From: James Neave
Sent: 06 March 2014 15:52
To: Nat Slade; Peter Cleveland
Subject: WSCC/096/13/F - Ford Waste Treatment Facility - Further Information
Attachments: WSCC Acoustic Consultant.pdf; Environment Agency response.pdf; Public Health England response.pdf

PROPOSED DEVELOPMENT AND OPERATION OF A WASTE TREATMENT FACILITY NEW CIRCULAR TECHNOLOGY PARK (FORMER FORD BLOCKWORKS), FORD AIRFIELD INDUSTRIAL ESTATE, FORD, ARUNDEL, WEST SUSSEX, BN18 0HY

Review of a Noise Impact Assessment relating to a Proposed Waste Treatment Facility at Ford, Sussex

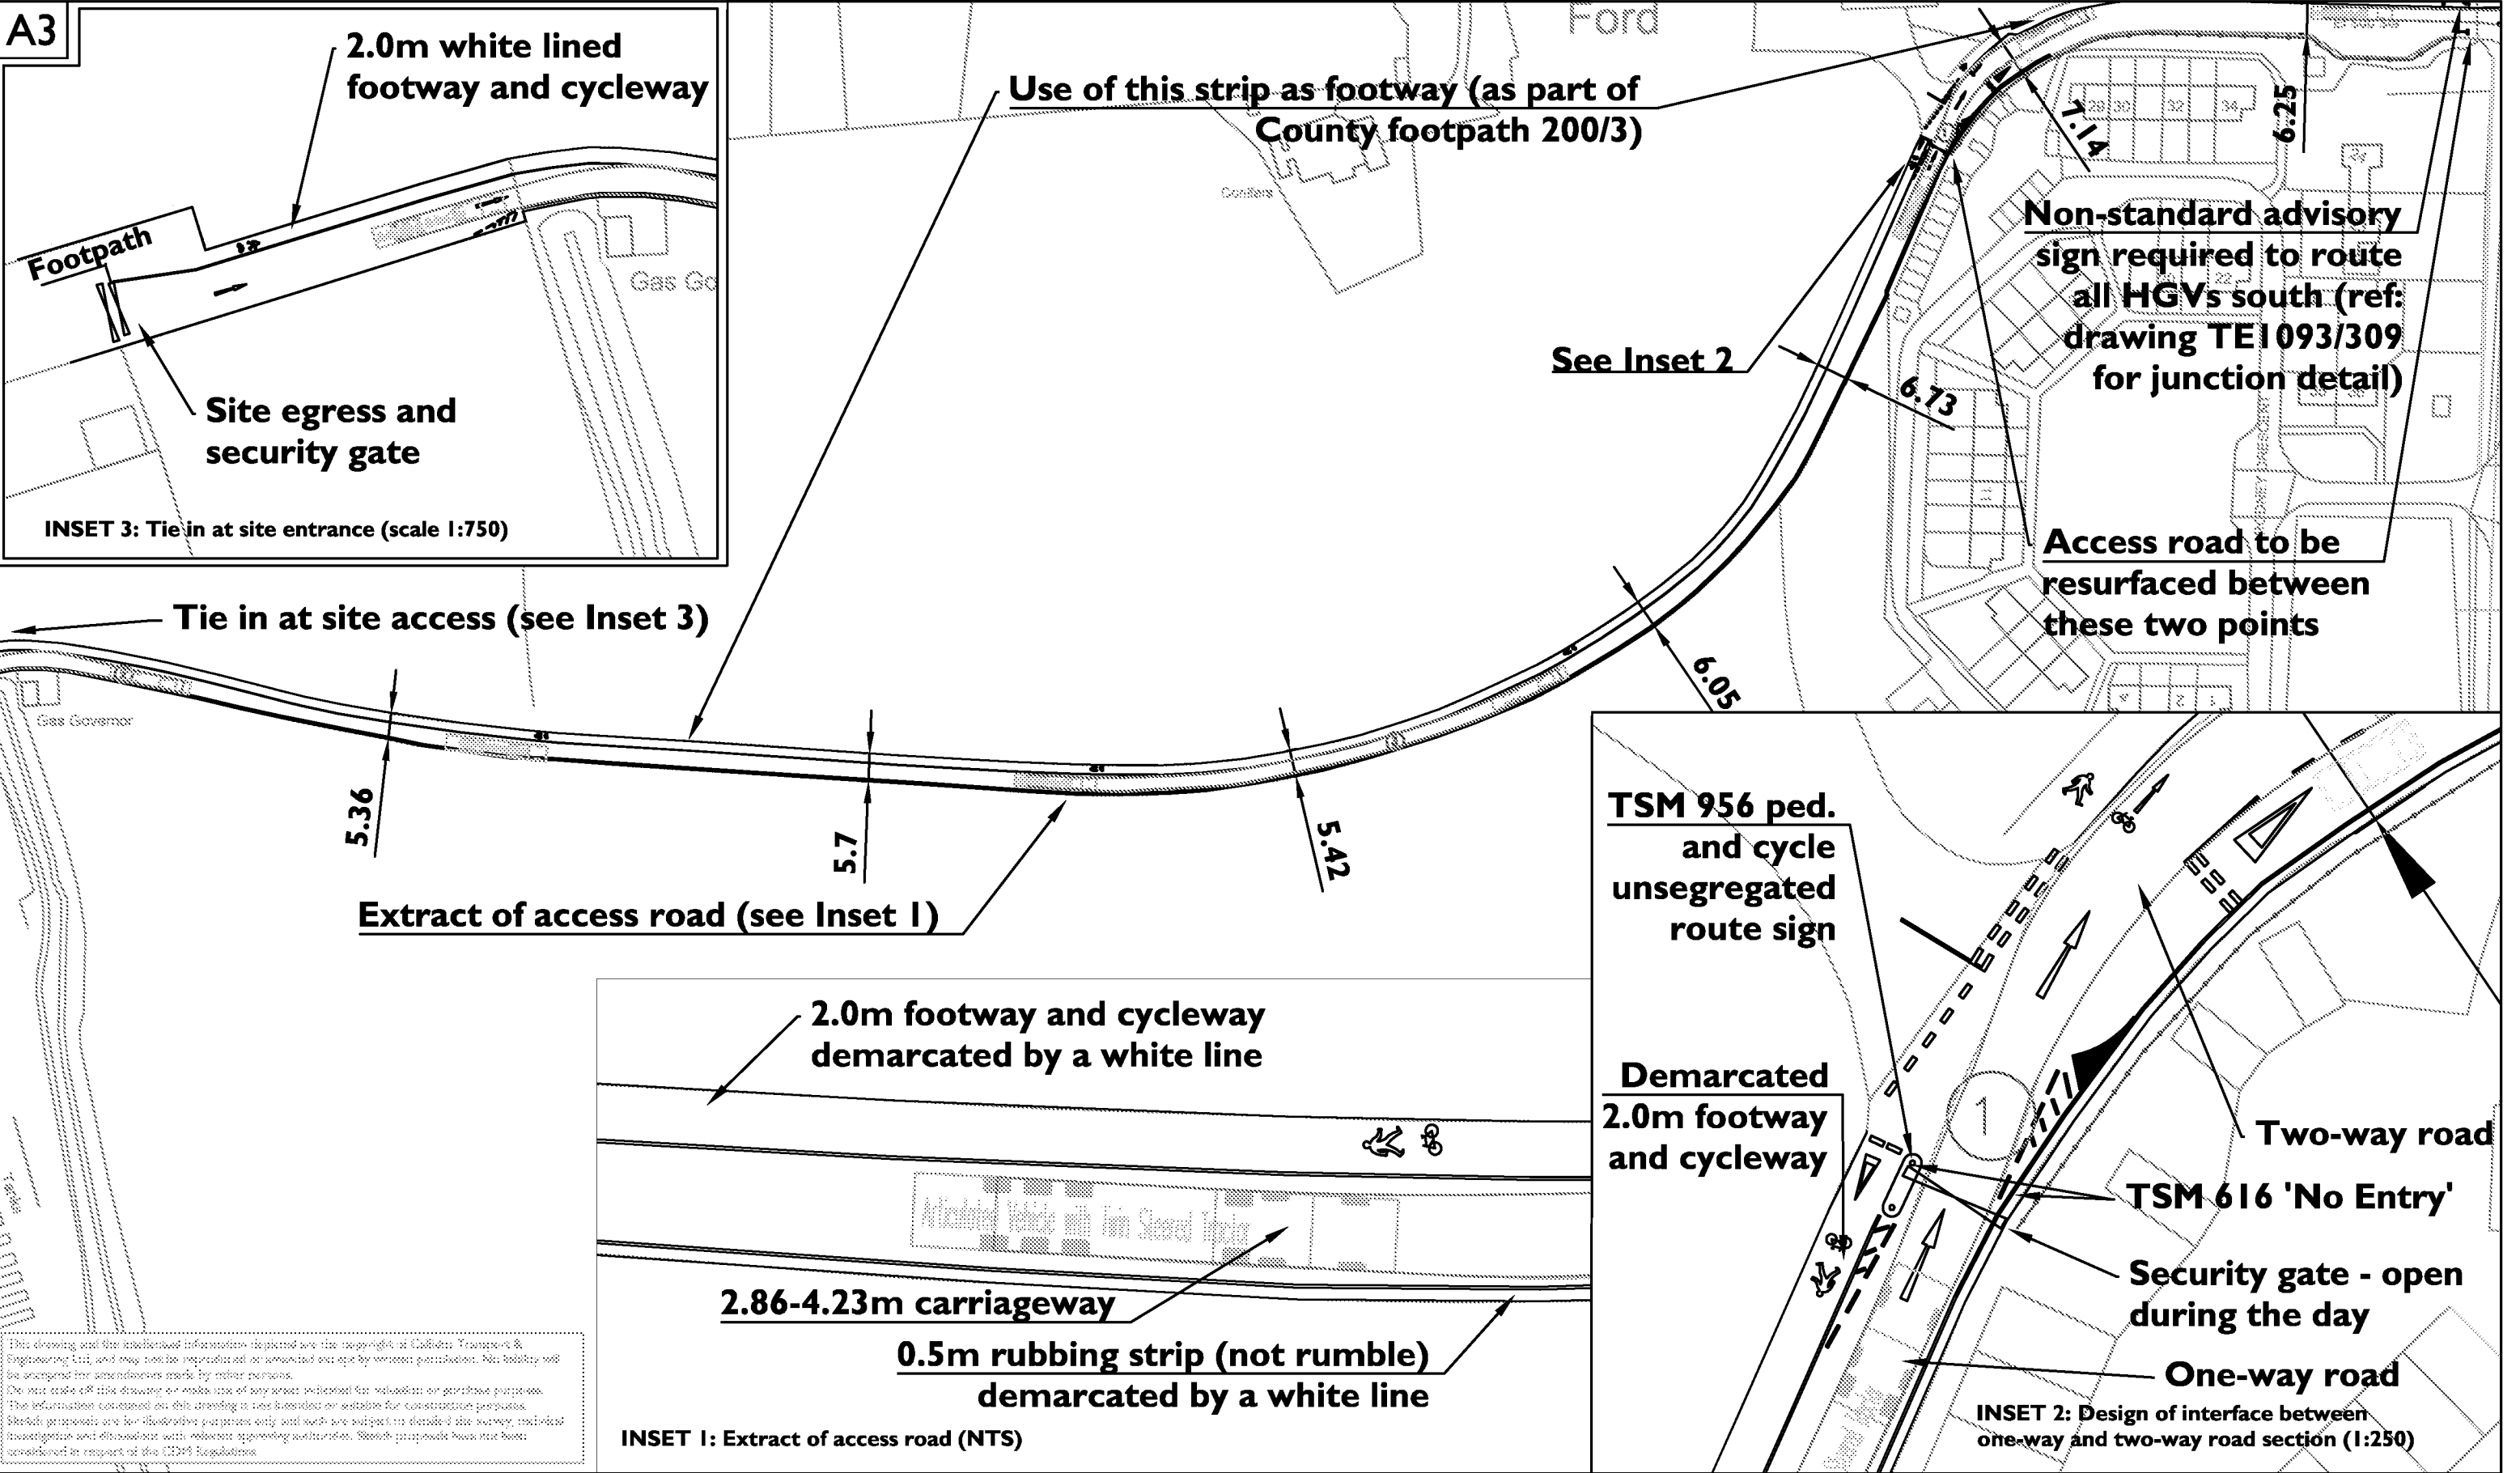
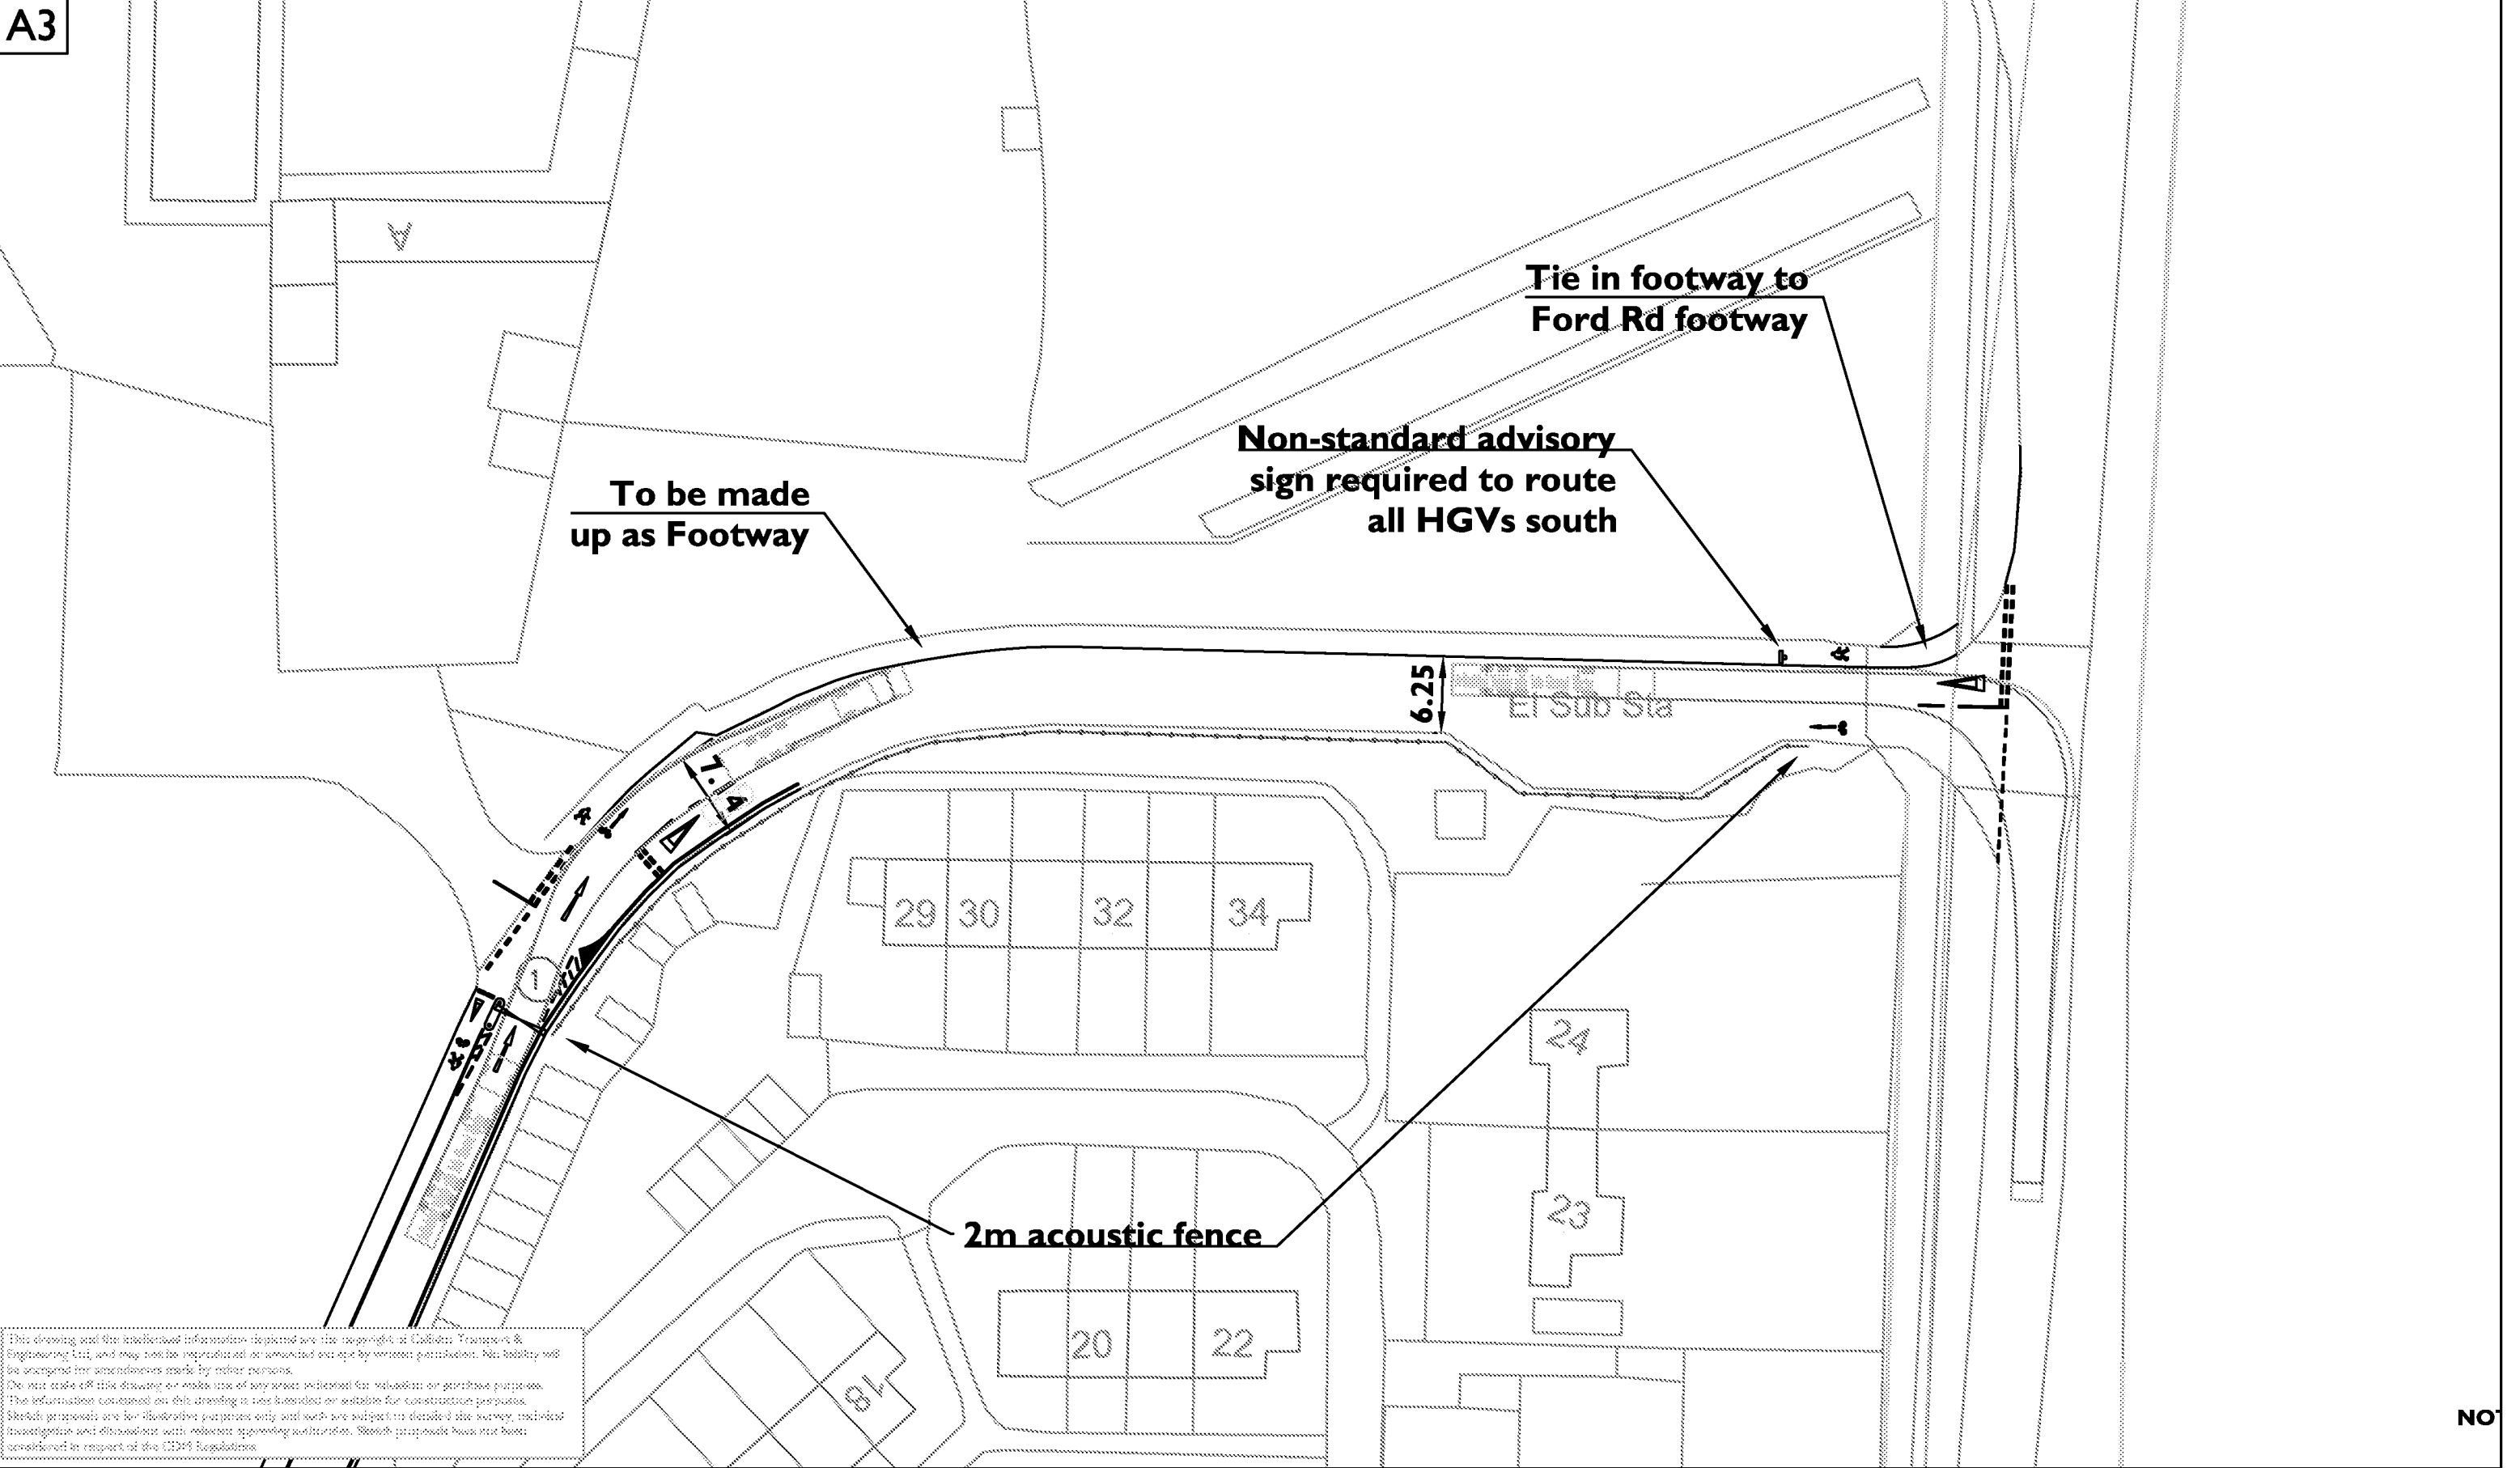
- Please also note the further info specifically addresses the stack height at paragraph 5.3.
- Please see appendix 4 (revised access layouts), this proposal seems to have a direct impact on the Flying Fortress Car-Park that seems not to have been laid out in accordance with ADC approved plans (F/1/04)
